**MAJOR PROJECT ASSESSMENT:
*Chris O'Brien Lifehouse at RPA
Bounded by Salisbury Road, Brown
Street, Missenden Road and Susan
Street, Camperdown, NSW
(MP10_0036)***

Director-General's
Environmental Assessment Report
Section 75I of the
Environmental Planning and Assessment Act 1979

December 2010

SOLAR STUDIES

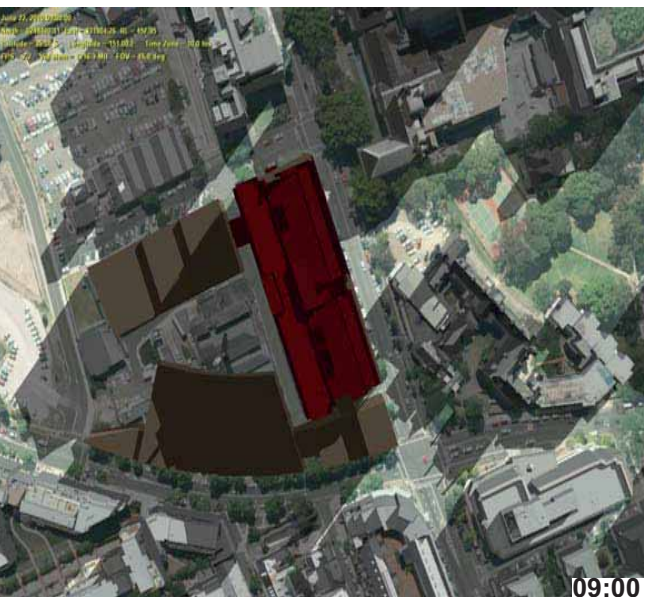
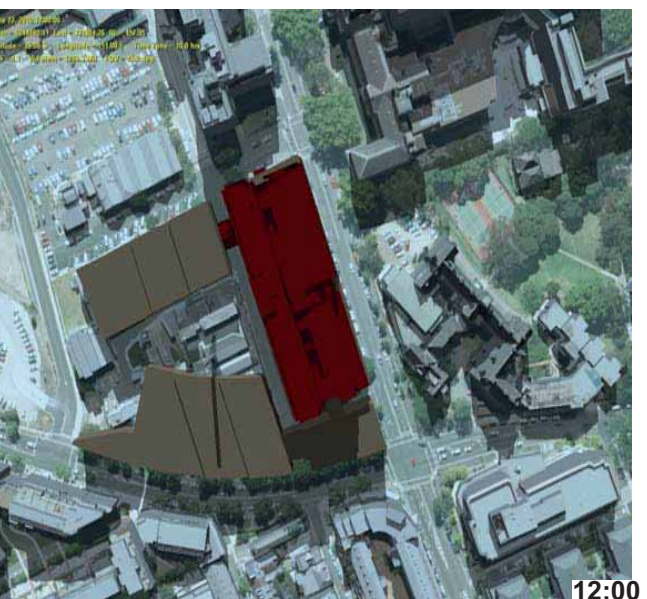
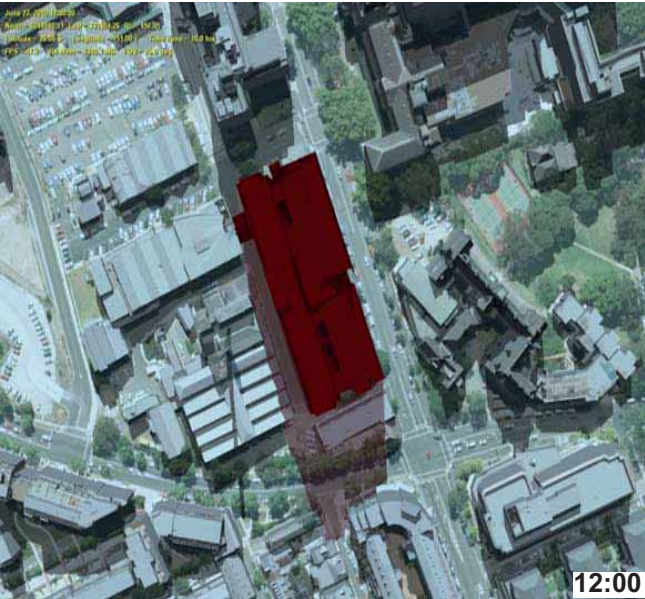
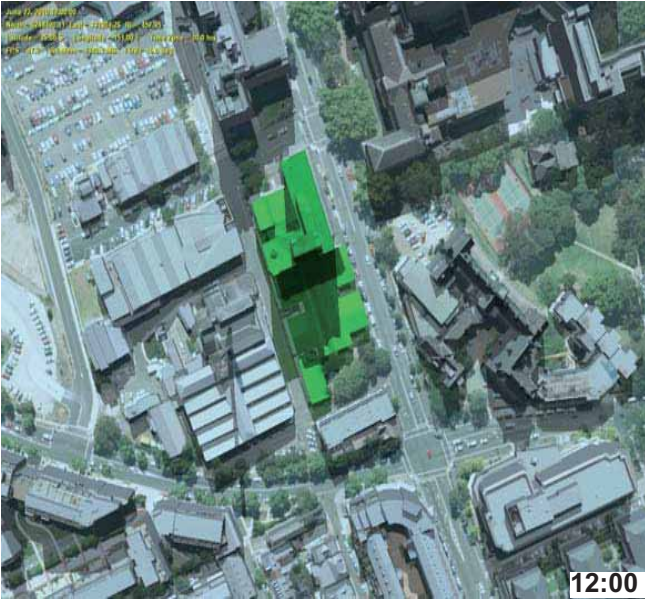
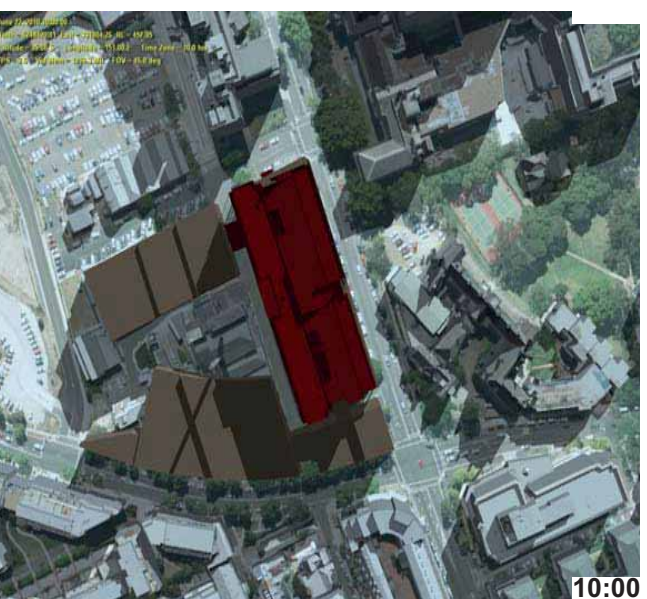
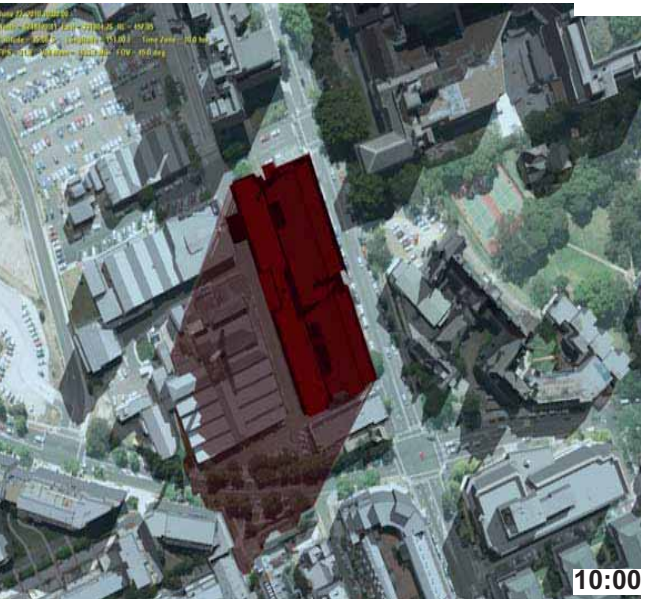
- The City has raised concerns about overshadowing, in particular shadows cast on residents south of Carillon Avenue. It was recommended that information be sought from the applicant as to the methodology of determining shadow impacts;
